From: Brian Banister
Sent: 26 November 2008 11:27
To: Planning.Responses
Subject: RE: Planning Consultation on: AB/147/08/

APPLICATION **AB/147/08/**
NO:

Registered: 12-NOV-08
Site 70A Tarrant Street Arundel
Address:

Description of Change of use from shop (A1) to domestic garage (C3)
Works:

PROPOSED FRONT ELEVATION

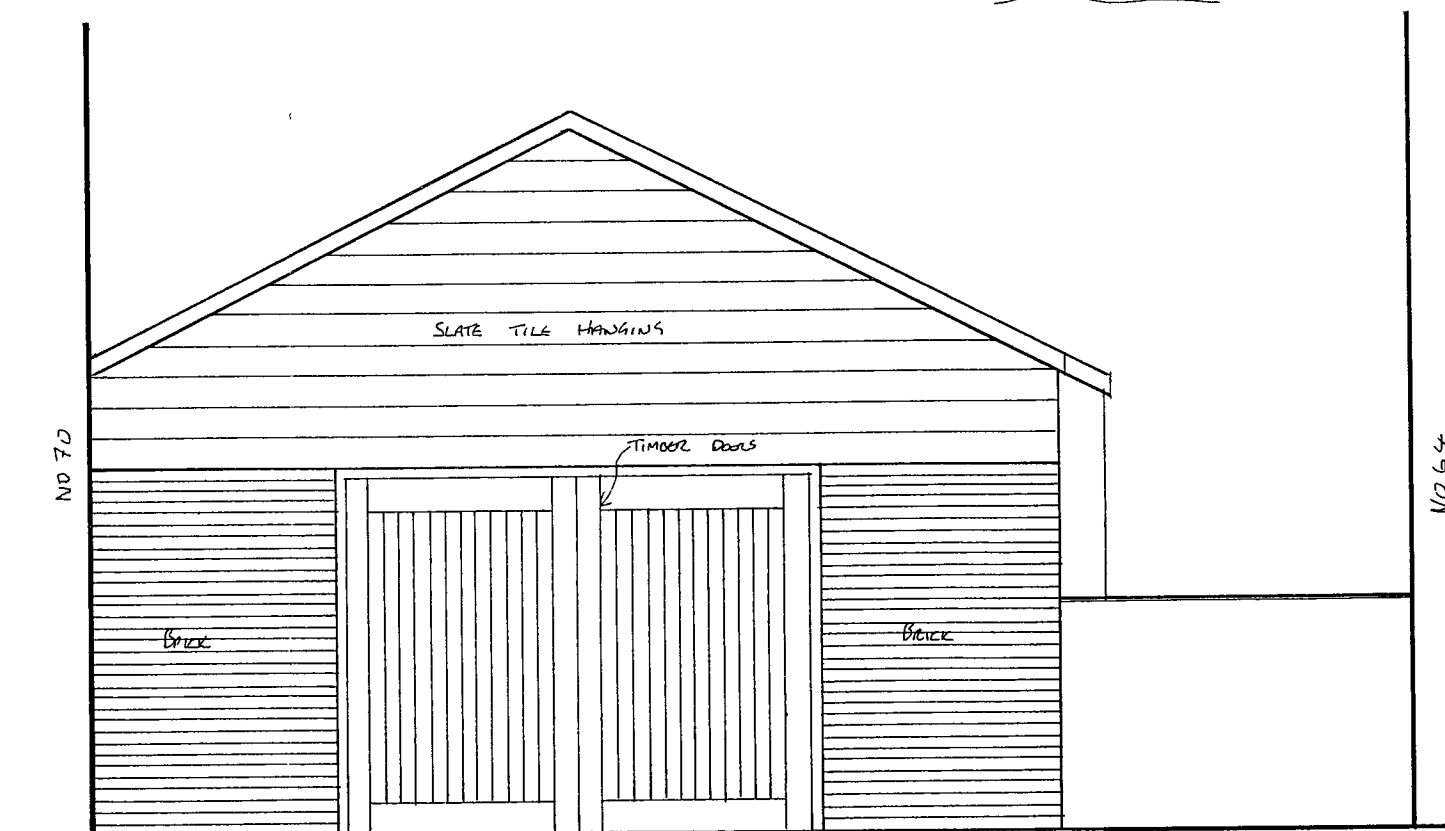
I wonder whether given the adjoining rendered and painted brick buildings whether it would be better to have painted render or painted English or Flemish coursed brickwork for those areas shown as brick on the front elevation. The boarding looks good.
